BRIEF DESCRIPTION OF REQUEST
Afra Construction, on behalf of West Mesa RV Park formerly known as Paradise RV Park, request Final Sign Off for Site Development Plan approved by EPC

REFERENCE: WEST MESA PARK – FORMERLY KNOW AS PARADISE RV PARK
PROJECT NO: 1008330 / EPC-40073 PHASE II. AND PROJECT NUMBER PR-2024-010907- DFT APPLICATION NUMBER SI-2024-01331.

Based on the NOTICE OF DECISION and recent comments from the DFT staff, we have addressed all the Conditions of Approval in **bold text** as follows:

A-01

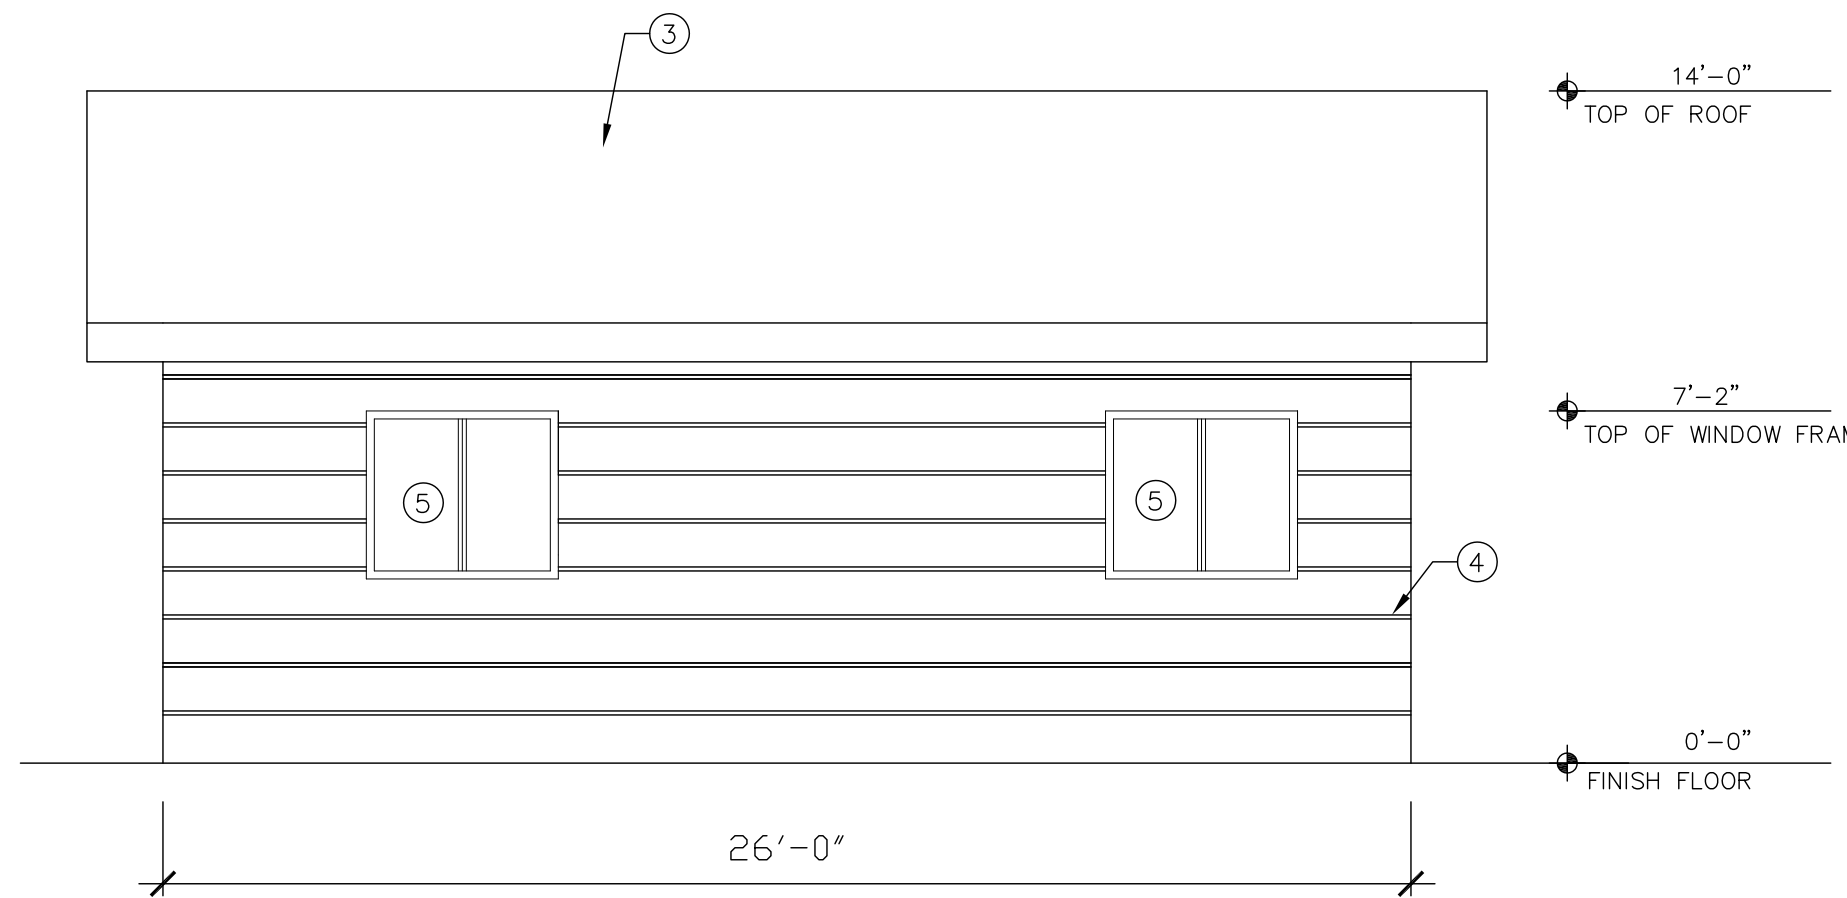
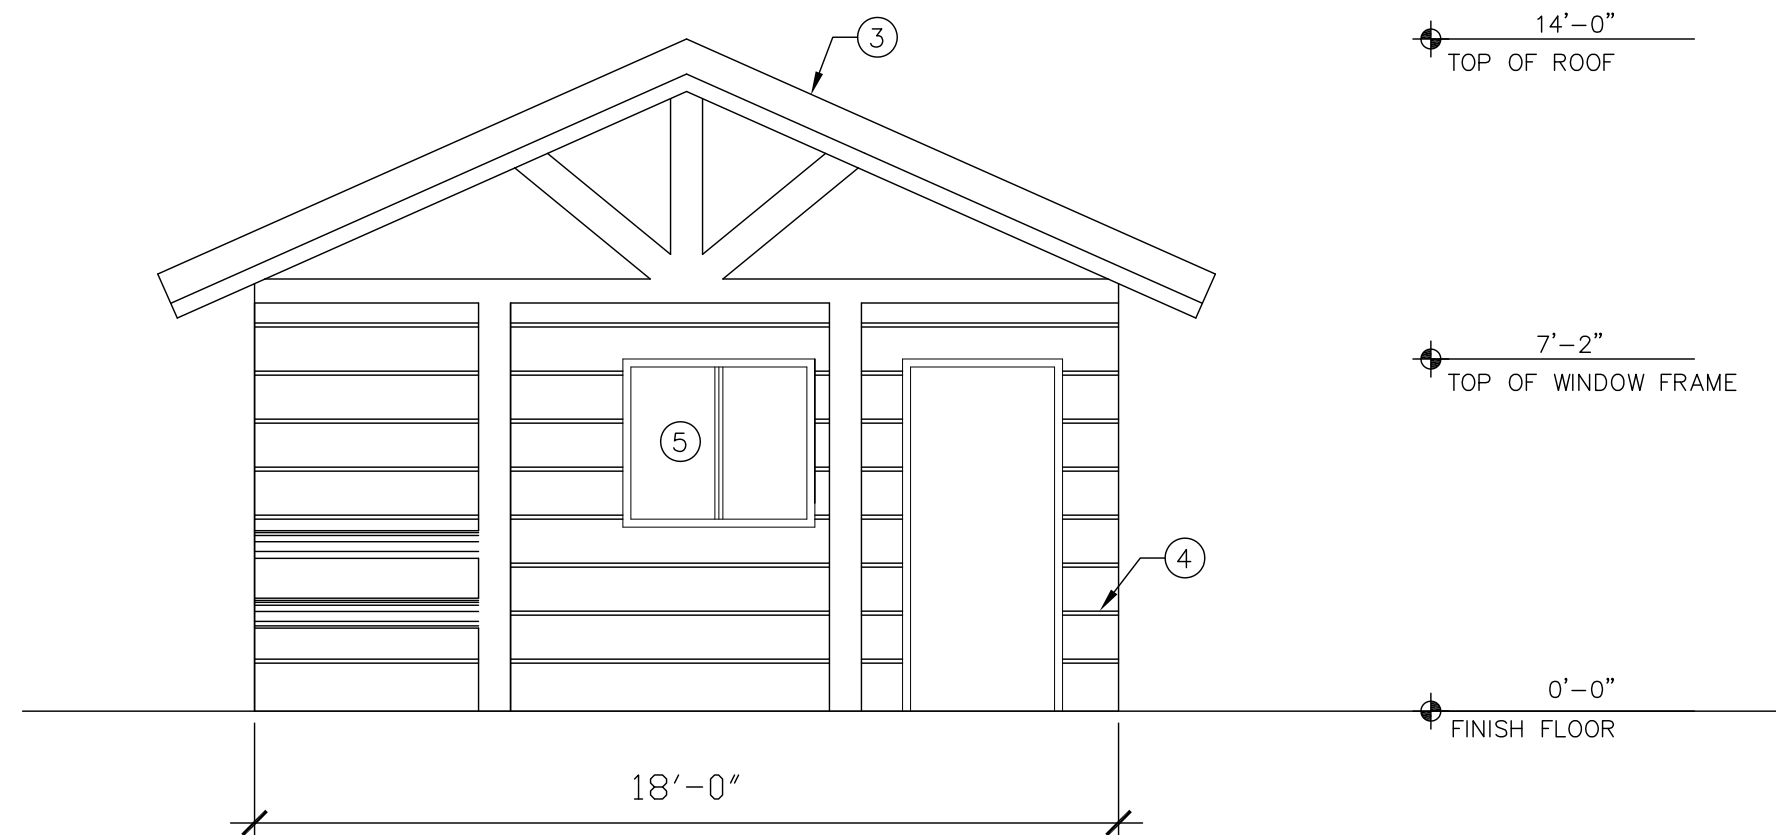
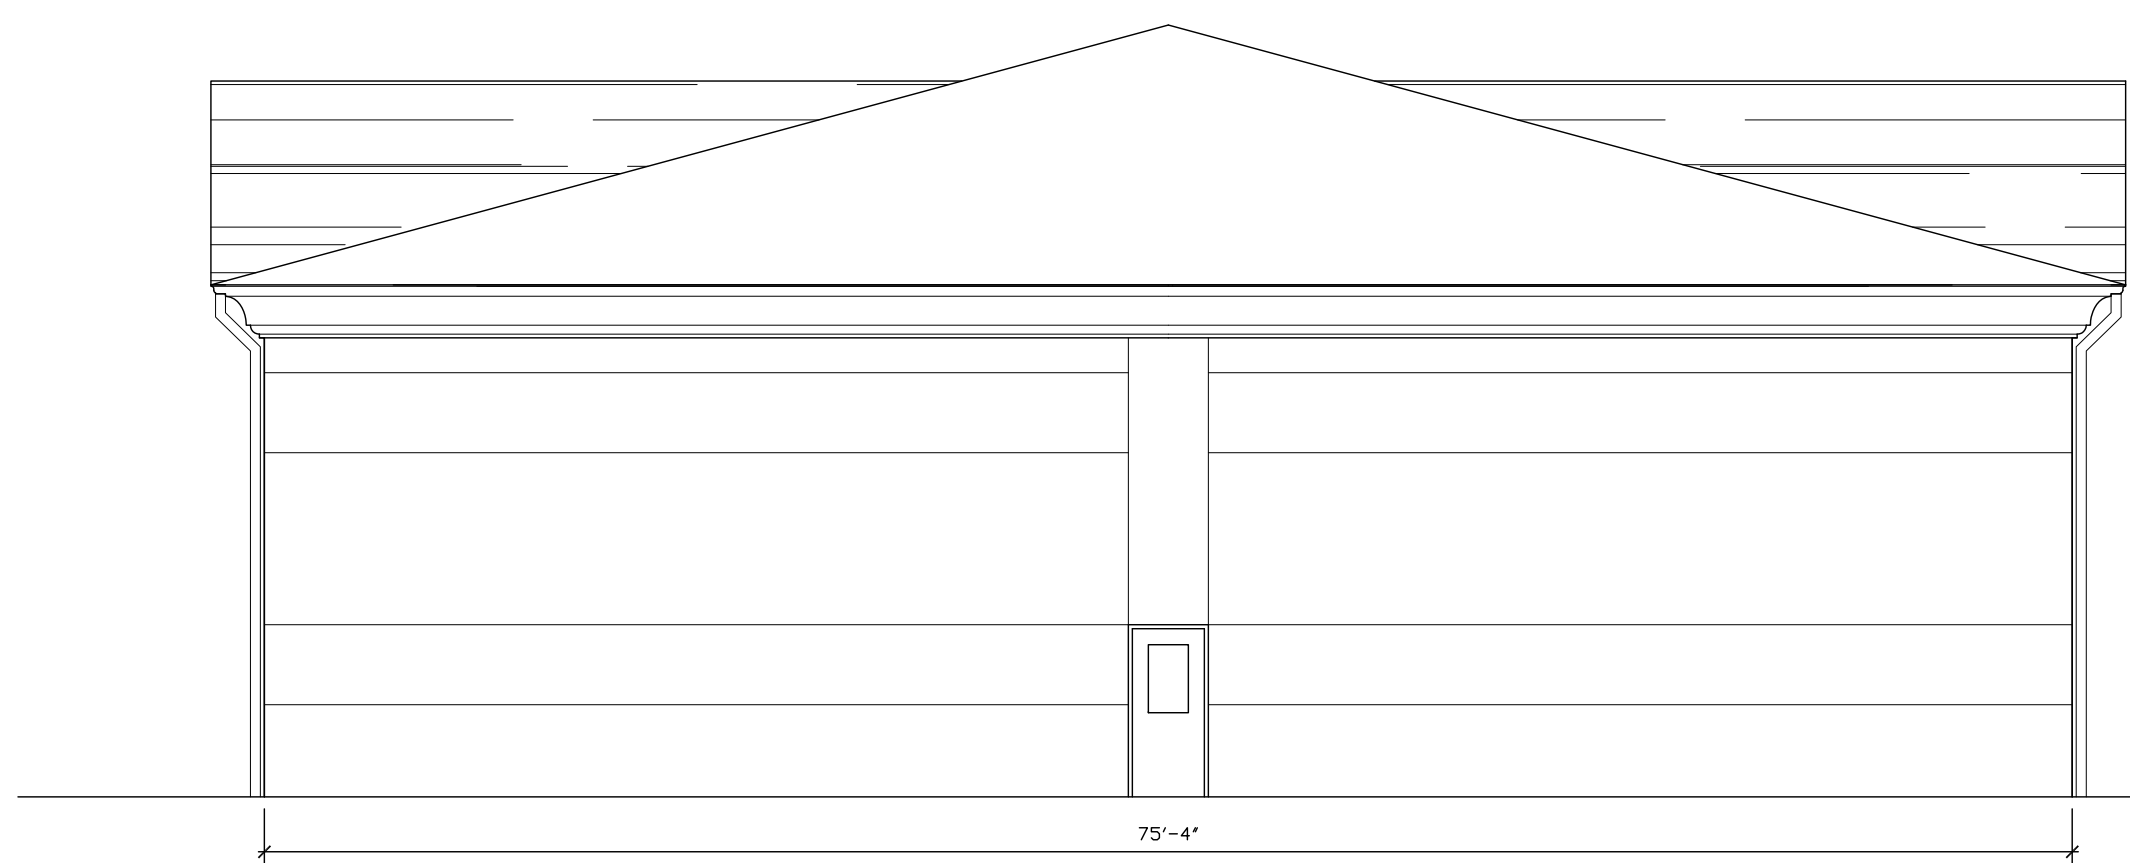
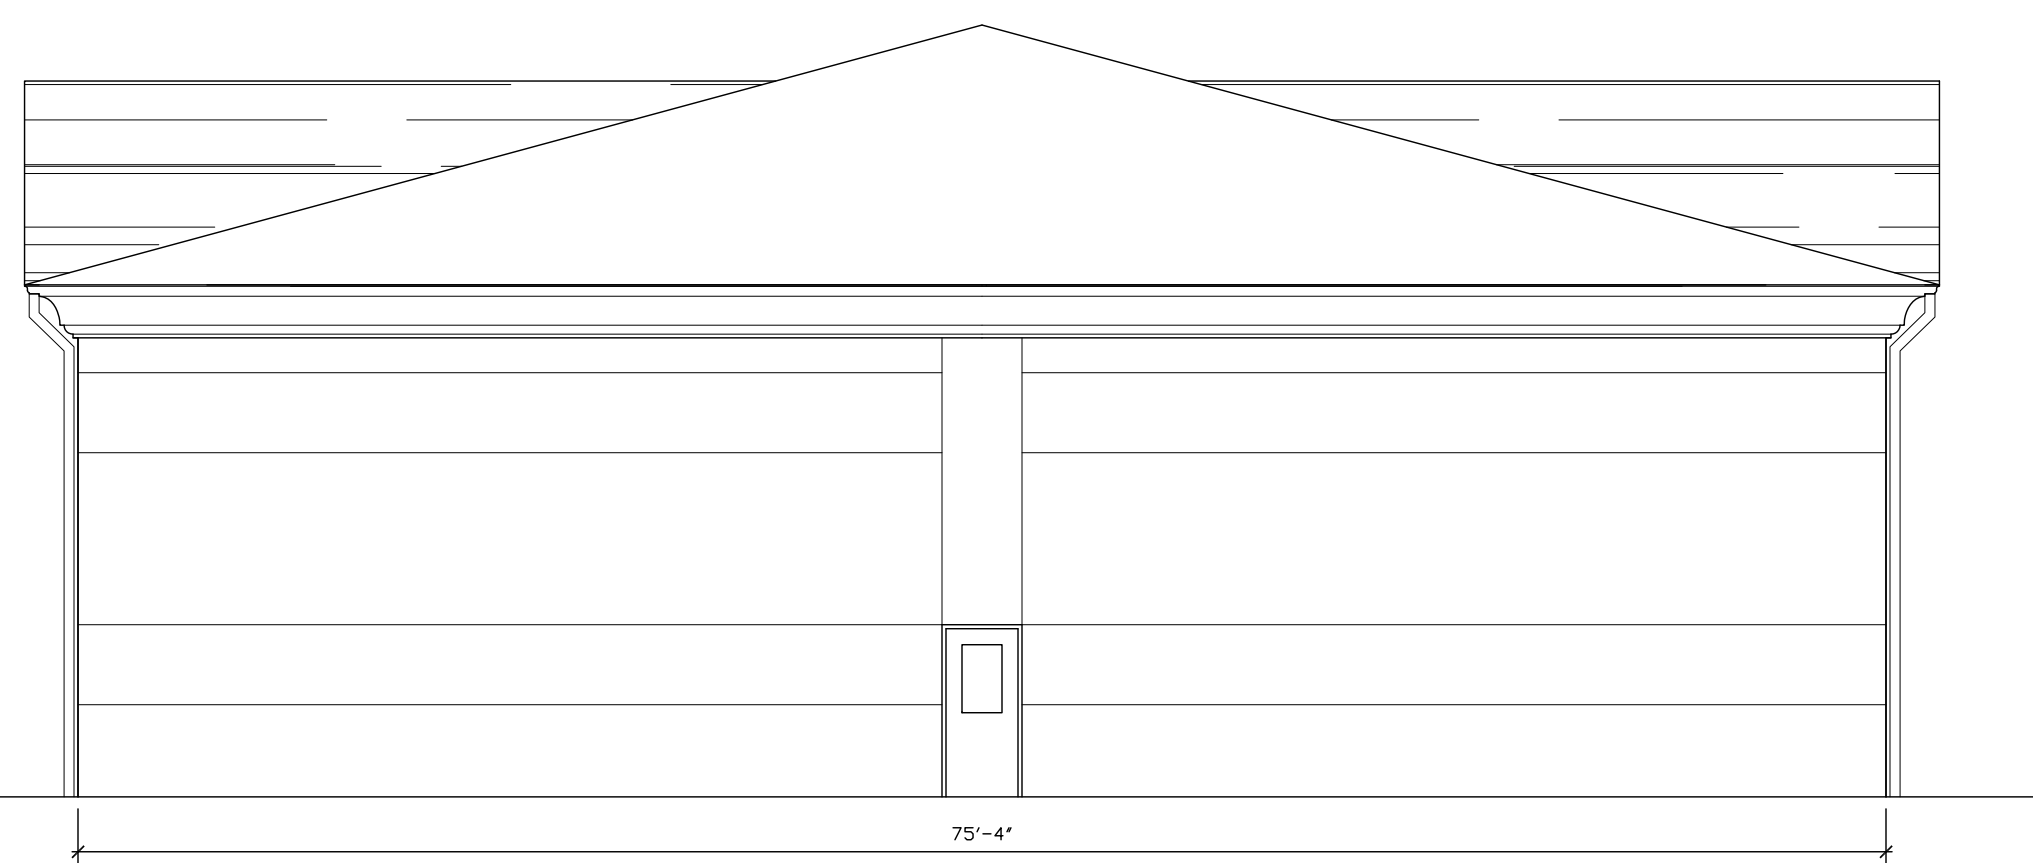
6. Building elevations for all four sides, with dimensions, shall be provided on the Elevation sheets. Details for the windows and doors, including dimensions, shall be provided on the detail sheet.

All dimensions are shown on Sheets AO-1 and AO-2.
